**WELWYN HATFIELD BOROUGH COUNCIL  
EXECUTIVE DIRECTOR - PLANNING, PUBLIC PROTECTION AND GOVERNANCE**

**DELEGATED APPLICATION**

**Application No:** 6/2022/2114/HOUSE  
**Location:** 9 South Drive Cuffley Potters Bar EN6 4HP  
**Proposal:** Installation of side dormers and erection of a single storey rear extension with loft space converted into habitable space  
**Officer:** Ms Kirsty Shirley

**Recommendation:** Refused

TITLE  
 ROOF PLANS

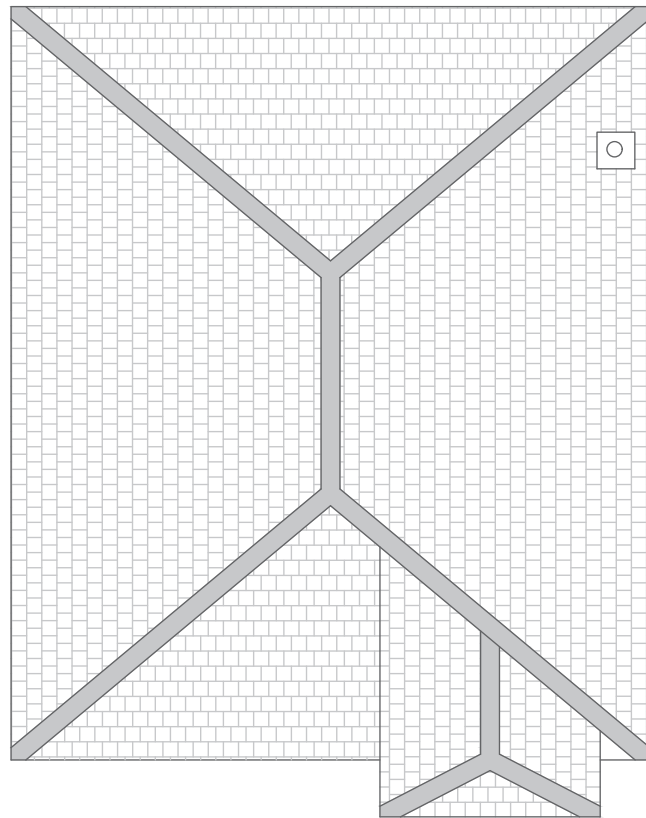
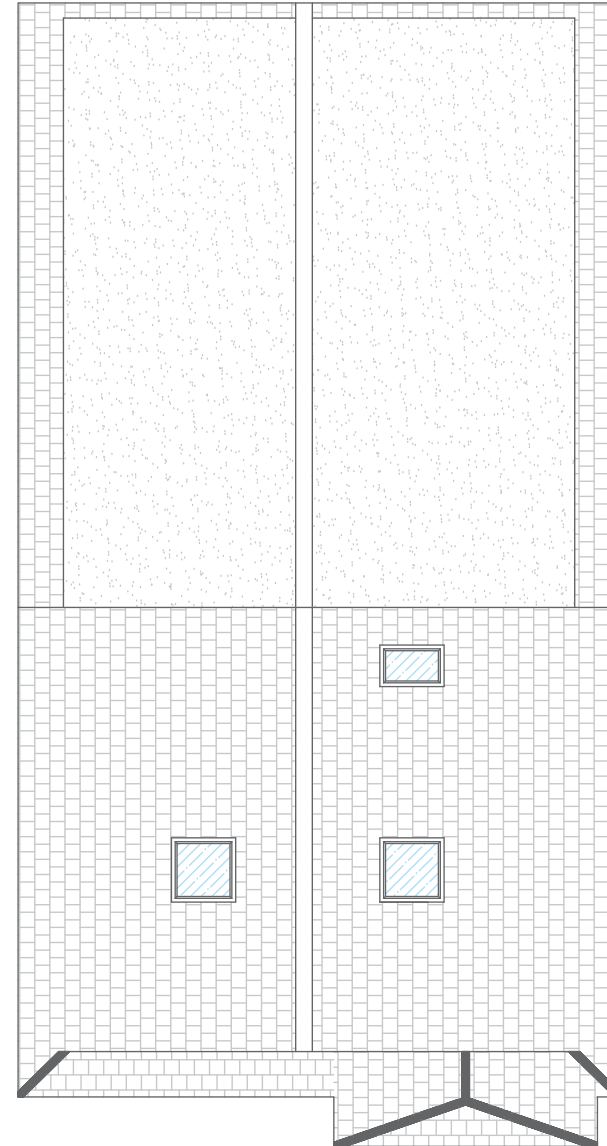
The development would increase the roof height of the dwelling by approximately 0.2m. Such an increase would be limited and would not result in the dwelling to appear unduly prominent within the street scene.

The two side facing dormer windows would be positioned a substantial distance from the front elevation and approximately 0.2m from the rear elevation. The side dormers would feature a flat roof, which would be set

<p>approximately 0.35m from the ridge height of the dwelling. Each side dormer would feature windows, with the dormer facing adjoining neighbour No. 7 featuring two windows and the dormer facing adjoining neighbour No. 11 featuring three windows. The windows would be similar in scale and design to the fenestration of the dwelling.</p> <p>However, the size, scale and positioning of the dormers would overwhelm the roof slope, appearing unduly prominent and detracting from the appearance of the dwelling. The dormers would add considerable massing to the roof, with the roof appearing top-heavy and overbearing towards the dwelling. The development would therefore represent poor design that would harm the character and appearance of both the application dwelling and wider area.</p> <p>The proposed development has therefore failed to overcome refusal reason 1 (poor standard of design) of application 6/2022/1414/HOUSE.</p>

TITLE
 PROPOSED ELEVATIONS

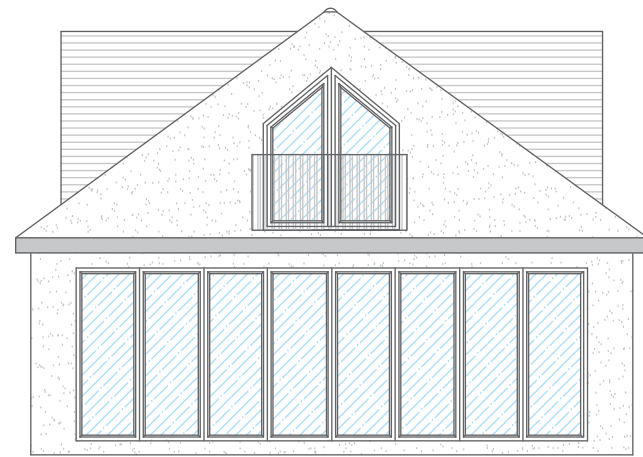
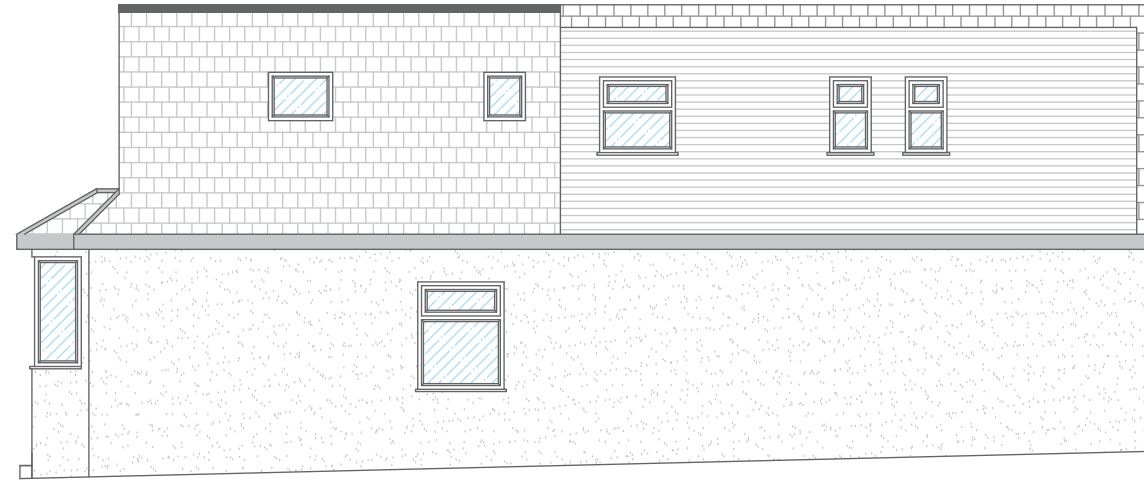
The rear extension would project approximately 4.7m from the rear elevation. The rear extension would continue the hipped form of the roof and would be set over 1m from the boundary line of adjoining neighbours. The scale, design and positioning of the rear extension would appear subservient towards the dwelling with limited views from the street scene.

1. The proposed development, by virtue of the dormers, would result in unduly dominant and overbearing additions to the dwelling that would fail to complement and reflect the design and appearance of the application dwelling. Accordingly, the proposed development represents a poor standard of design which is harmful to the appearance of the application dwelling and the character of the area, contrary to Policies D1, D2 and GBSP2 of the Welwyn Hatfield District Plan; Policies SP9 and SADM11 of the Emerging Local Plan; the Supplementary Design Guidance; and the National Planning Policy Framework.

TITLE | PROPOSED FLOOR PLANS

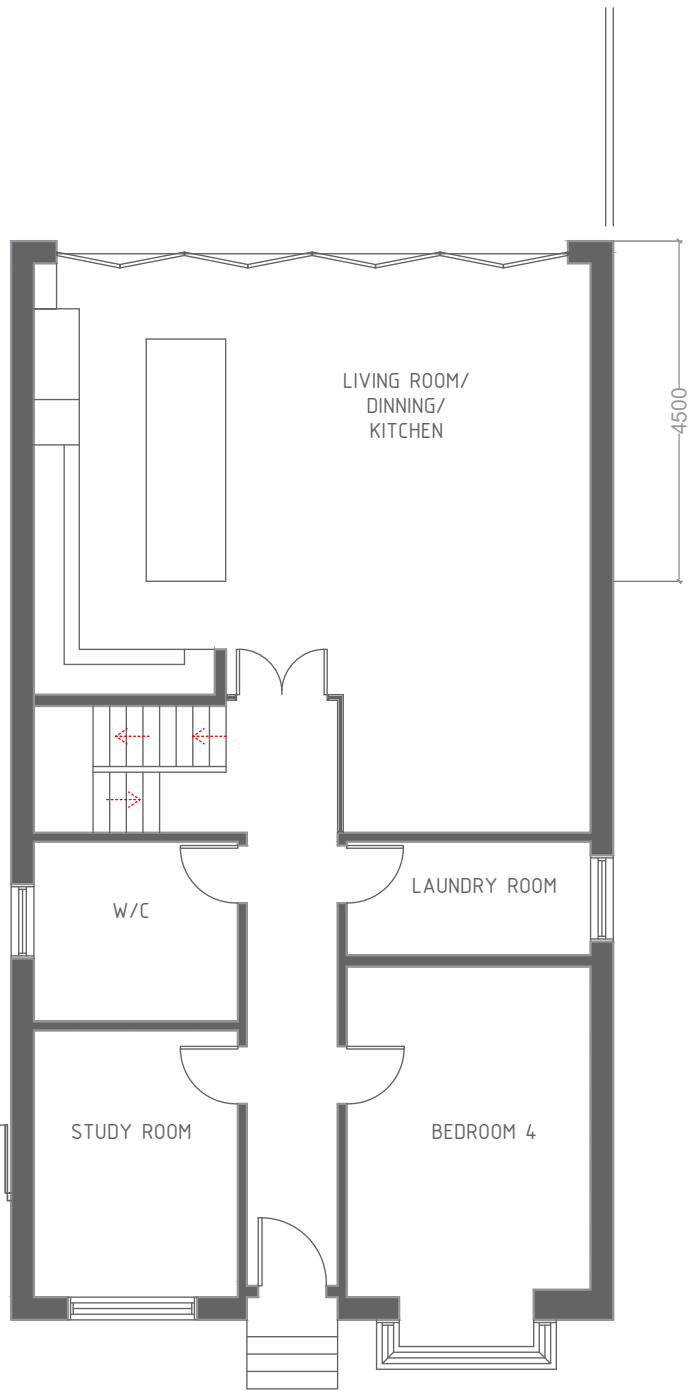
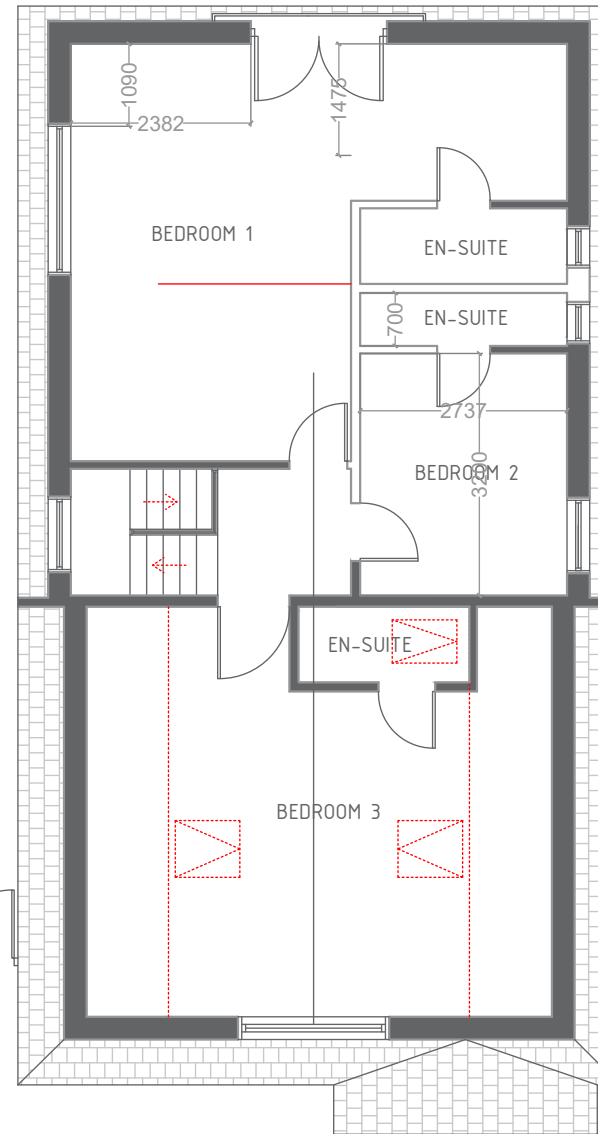
<p><b>Access, car parking and highway considerations</b></p>	<p>Paragraph 107 of the NPPF states that if setting local parking standards authorities should take into account the accessibility of the development; the type, mix and use of the development; the availability of and opportunities for public transport; local car ownership levels; and the need to ensure an adequate provision of spaces for charging plug-in and other ultra-low emission vehicles.</p> <p>The Council's Interim Car Parking and Garage Policy confirms that planning applications will be determined on a case-by-case basis to achieve a sensible level of parking provision taking account of existing SPG standards, NPPF guidance, the relevant circumstances of the proposal, its site context and its wider surroundings.</p> <p>The proposal would increase amount of bedrooms within the dwelling from three to four. The Council's Parking Standards advises dwellings with four or more bedrooms in this location should provide parking for three vehicles. The application site benefits from a front hardstanding suitable to park one vehicle. The site also features a shared driveway with No. 11 which leads to a garage to the rear of the application site. The garage is approximately 3.2m wide and 7.7m long, and so is suitably sized to park a vehicle. Due to the shared</p>

<p>driveway however, a further vehicle could not park within the site without obstructing access to the garage of No. 11.</p> <p>South Drive has had issues with car parking as evidenced by car parking restrictions in place from 11am – 1pm Monday to Friday in the area. An under provision of on-site car parking is therefore not acceptable in this location.</p> <p>This application has therefore not overcome previous refusal reason 2 of application 6/2022/1414/HOUSE as the proposal would result in an unacceptable under provision of car parking spaces. The proposal therefore fails to comply with Policies D1 and M14 of the Welwyn Hatfield District Plan 2005; the Supplementary Design Guidance 2005; the Supplementary Planning Guidance on Parking Standards 2004; and the National Planning Policy Framework.</p>
<p><b>Conclusion</b></p>	
<p>As it was considered under refused application 6/2022/1414/HOUSE, the proposed development, by virtue of the dormers, would result in unduly dominant and overbearing additions to the dwelling that would fail to complement and reflect the design and appearance of the application dwelling. Accordingly, the proposed development represents a poor standard of design which is harmful to the appearance of the application dwelling and the character of the area, contrary to Policies D1, D2 and GBSP2 of the Welwyn Hatfield District Plan; Policies SP9 and SADM11 of the Emerging Local Plan; the Supplementary Design Guidance; and the National Planning Policy Framework.</p> <p>Furthermore, the proposal fails to provide adequate on-site parking to accommodate the proposed development, failing to comply with Policies D1 and M14 of the Welwyn Hatfield District Plan; the Supplementary Design Guidance; the Supplementary Planning Guidance on Parking Standards; and the National Planning Policy Framework.</p>

2. The proposal fails to provide adequate on-site parking to accommodate the proposed development, failing to comply with Policies D1 and M14 of the Welwyn Hatfield District Plan; the Supplementary Design Guidance; the Supplementary Planning Guidance on Parking Standards; and the National Planning Policy Framework.
